Appeal Decision

Appeal Ref: 6008048

Lowlands, Hurn Bank, Holbeach Hurn, Spalding, Lincs, PE12 8JG

- The appeal is made under section 78 of the Town and Country Planning Act 1990 (as amended) against a refusal to grant planning permission.
 - The appeal is made by Mr and Mrs J Pateman against the decision of South Holland District Council.
 - The application Ref is H09-0011-26.
 - The development proposed is a domestic garage.
-

Drawing
 FLOOR PLAN - PROPOSED
 ELEVATIONS - PROPOSED
 SITE & LOCATION PLAN

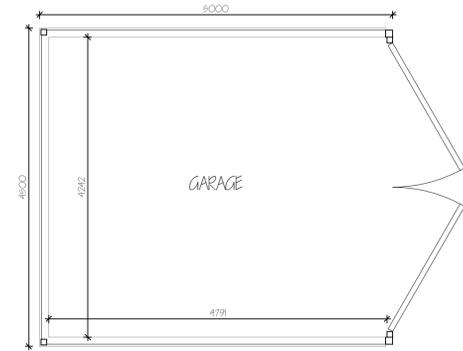
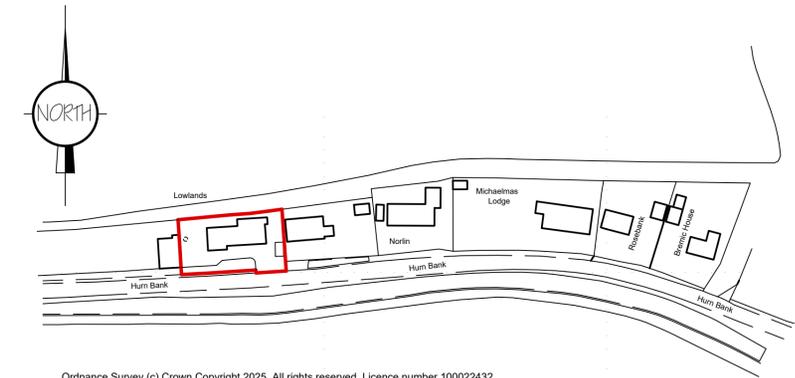
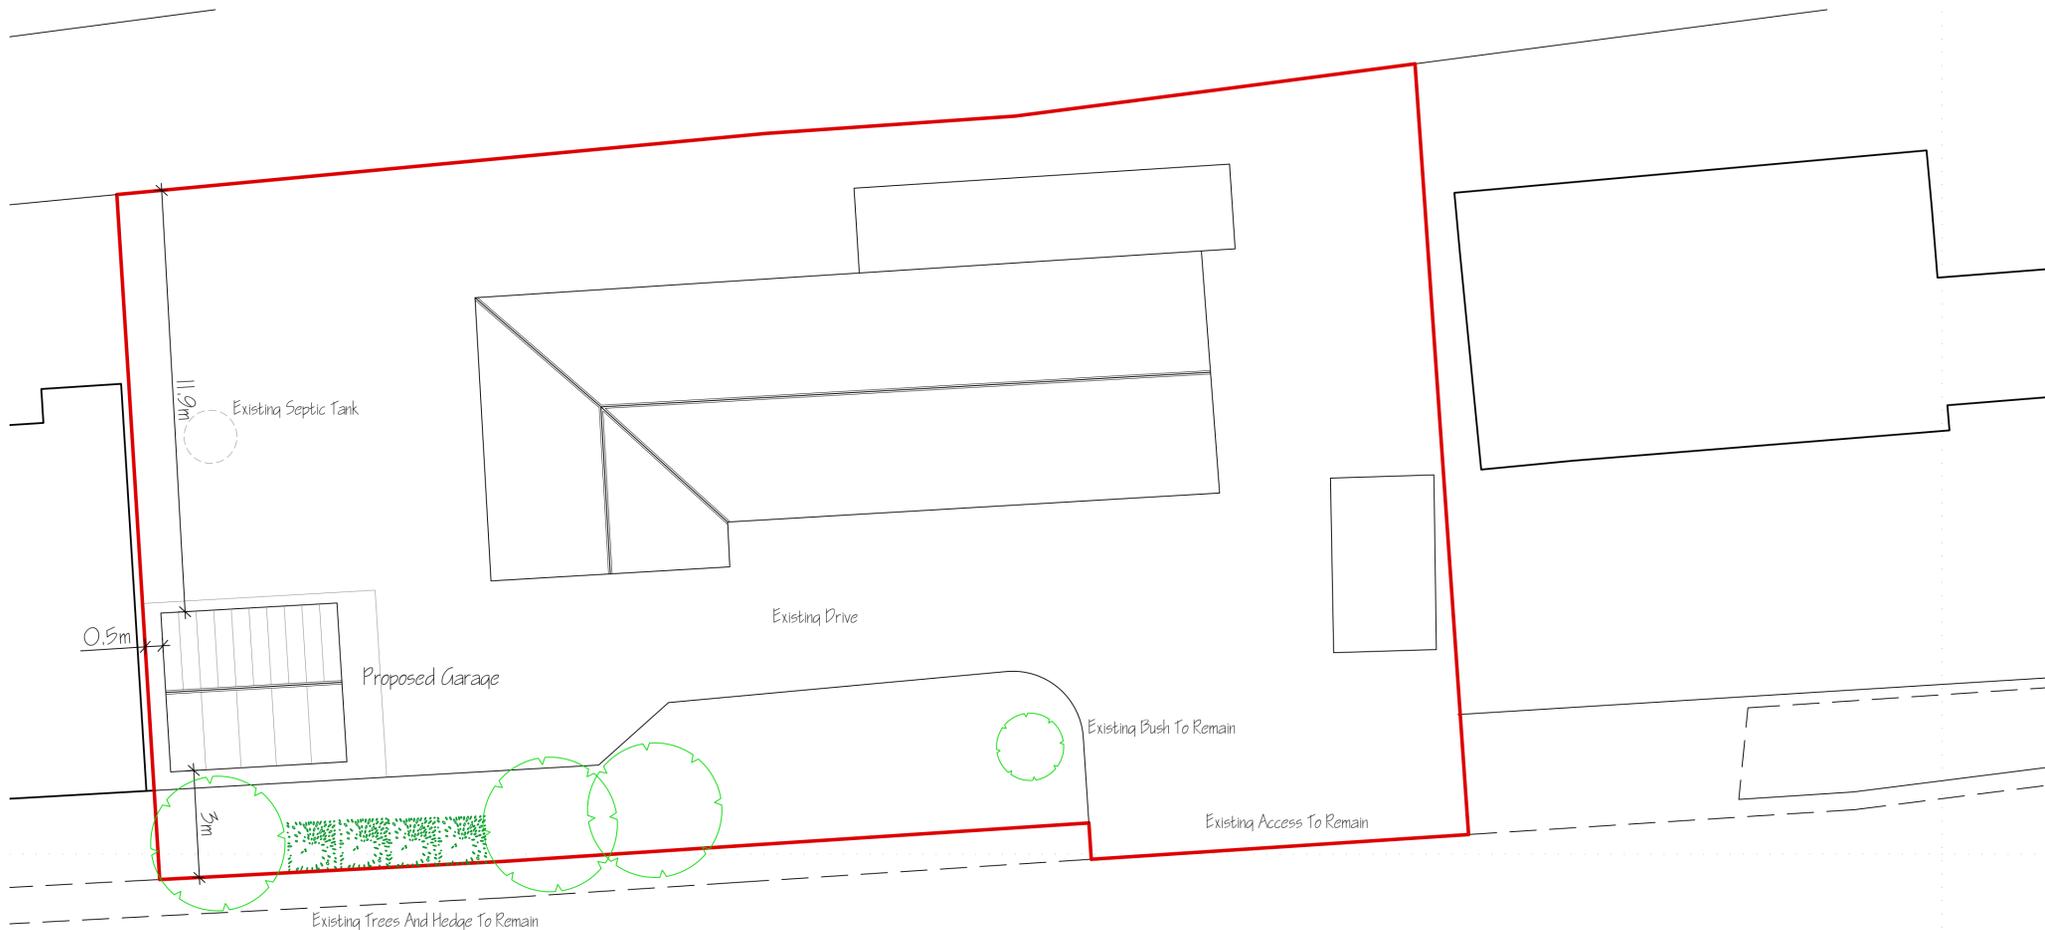
3. Lowlands is a traditional, detached bungalow that I saw is currently undergoing a process of renovation, the end one of three similar properties on Hurn Bank in an edge of village location with fields opposite. The dwellings are set on wide plots with generous spaces between buildings and are set back from the road behind front gardens.
4. The appeal dwelling has a long frontage to the road and is set back from it at a significantly lower ground level. The driveway runs parallel to the road across the frontage of the bungalow. The proposed garage would be sited at the end of the driveway in the front part of the plot and positioned against the high, leafy side boundary. It would be at the same ground level as the bungalow and below that of the road. It would have a pitched roof with its doors and gable end facing the driveway.

5. A high hedge, trees and a fence along part of the front boundary would provide some screening from the road although it would be seen in the approach from the east. I saw that the adjacent bungalow has a detached single garage with a pitched roof and other dwellings in the village have detached garages. Whilst those are set back from the road, they are generally more visible than the proposed garage would be.

6. At 5m x 4m and with a height of 3.5m, the garage would be significantly smaller in scale than the existing bungalow and its pitched roof form would reflect the pitched and gabled roof form of the bungalow. The proposed materials of oak feather edge boarding would be appropriate in this rural location and the proposed slate tiles would match those of one of the nearby other bungalows and could be replicated in the renovation of the main part of the dwelling.

7. Although the proposal would be set forward of the building line of the bungalow, its discreet siting at the side of the plot on lower ground, together with its appropriate appearance mean that it would not be unduly prominent in the street scene and would sit comfortably next to the existing bungalow and within its surroundings.

8. I conclude therefore that it would not result in harm to the character and appearance of the area and would accord with development plan policies 2 and 3 of the South East Lincolnshire Local Plan 2011-2036 (adopted 2019) which together seek to ensure that proposals take into account considerations such as quality of design and the impact on the character and appearance of the area.
